STATUTORY PLANNING CONSULTATION RESPONSE

Application Number:	3/2026/0214
Proposal:	Proposed erection of 26 affordable dwellings with associated access, gardens, parking and landscaping.
Location:	Land at Albany Drive Copster Green BB1 9EH

Objection 01 – Inadequate Surface Water Sustainable Drainage Strategy

Impermeable Area & Flood Route Plan

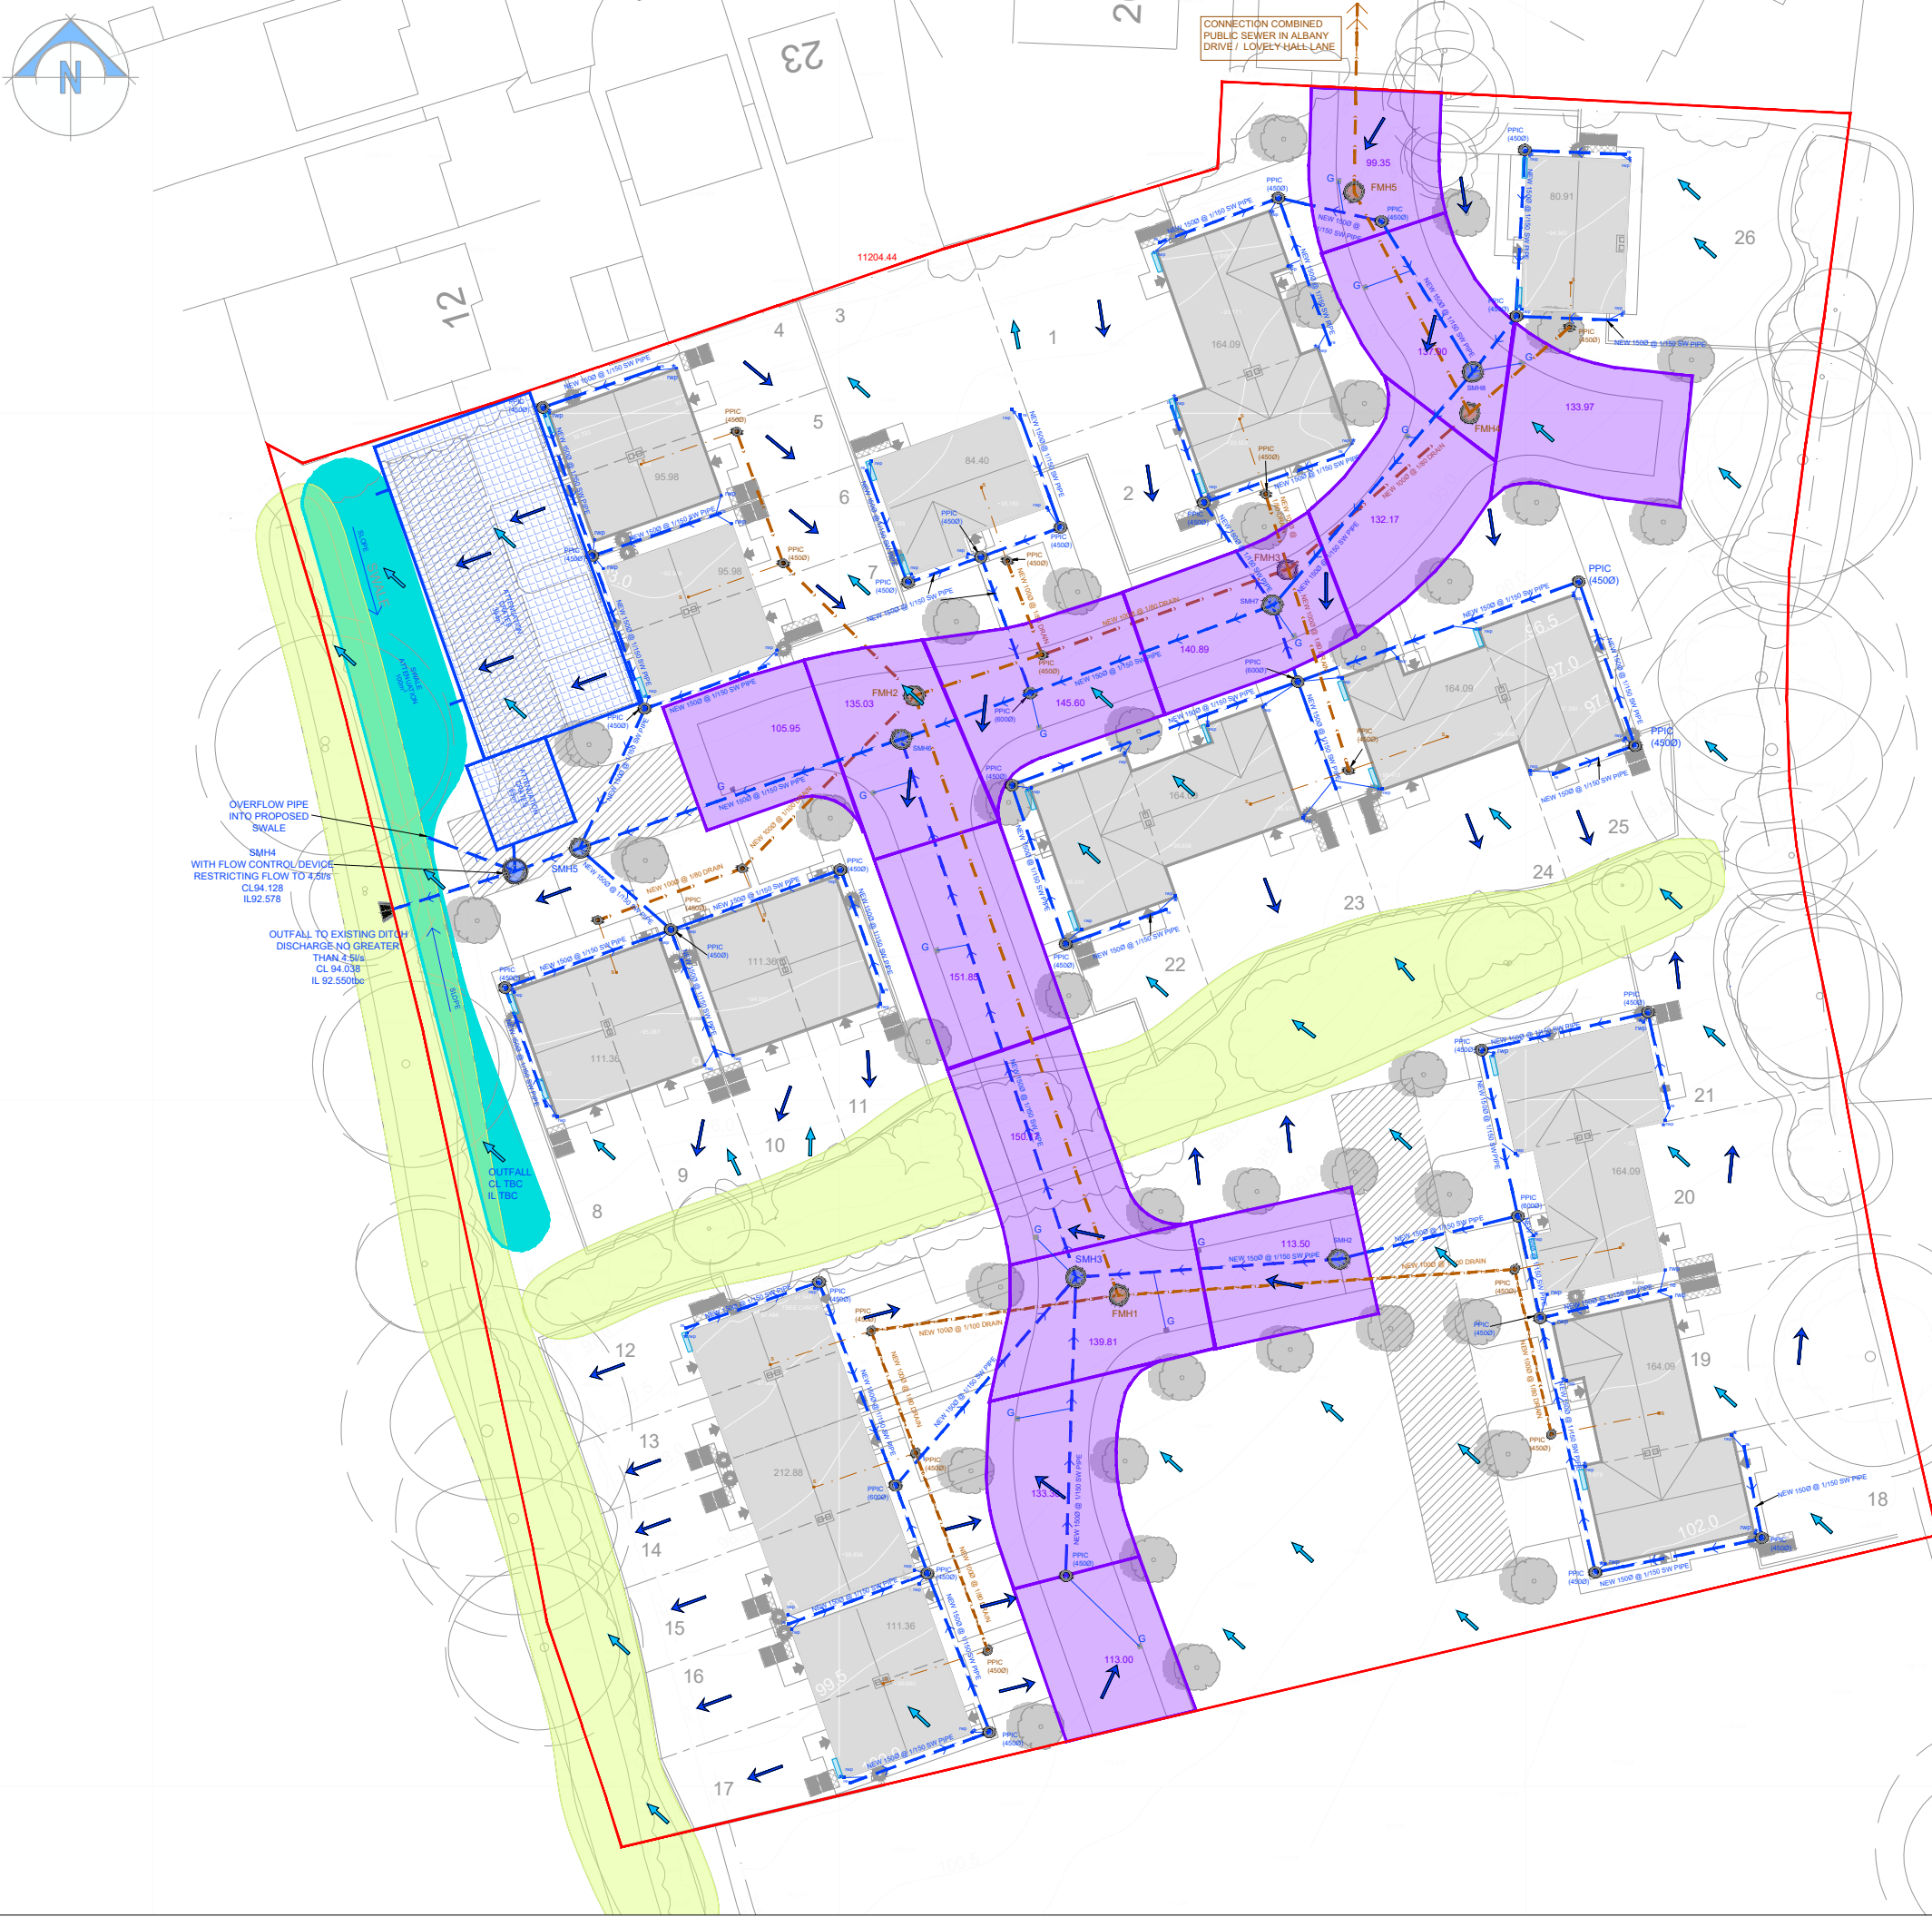
The submitted drainage strategy sizes the SuDS based only on the impermeable area of the site (approximately 0.562 ha), excluding the remaining permeable areas of the site, but calculates the discharge rate (9l/s) based on the approximate full 1.120 ha site area. Standard 3 requires that the entire development area that could potentially drain to the proposed surface water drainage system in an extreme

event shall be used for estimating greenfield runoff rates and volumes (including both permeable and impermeable surfaces). For the avoidance of doubt, the runoff area used in any of the runoff estimation methods should be consistent.

- For the avoidance of doubt, at present the applicant proposes to discharge surface water at 9l/s, this figure has been derived by utilising the whole site area as the contributing area, however the applicant only intends to positively drain 0.562ha, therefore the applicant is expected to calculate the greenfield runoff rate and volume based on this contributing area and then ensure that the post development surface water mimics the greenfield situation and provides the appropriate storage volumes required and evidence to demonstrate how surface water runoff from non-drained areas will be managed. Alternatively, the applicant can proceed with its proposals to discharge at 9l/s, however the applicant will be expected to demonstrate how the surface water drainage system has been designed to positively drain the whole site area. As outlined in Section 24.10 of The SuDS Manual, the runoff area used in any of the runoff estimation methods should be consistent with the post development contributing area.

- There may be some areas like the proposed swale which will contribute to the drainage system, in which case these areas should be included in the contributing area.

The applicant must design their SuDS with an appropriate estimation of the area contributing to the drainage system, both permeable and impermeable, with evidence of this area provided through an appropriate contributing area plan, or otherwise demonstrate how surface water runoff from non-drained areas will be managed without contributing to the drainage system and without increasing flood risk onsite or elsewhere.
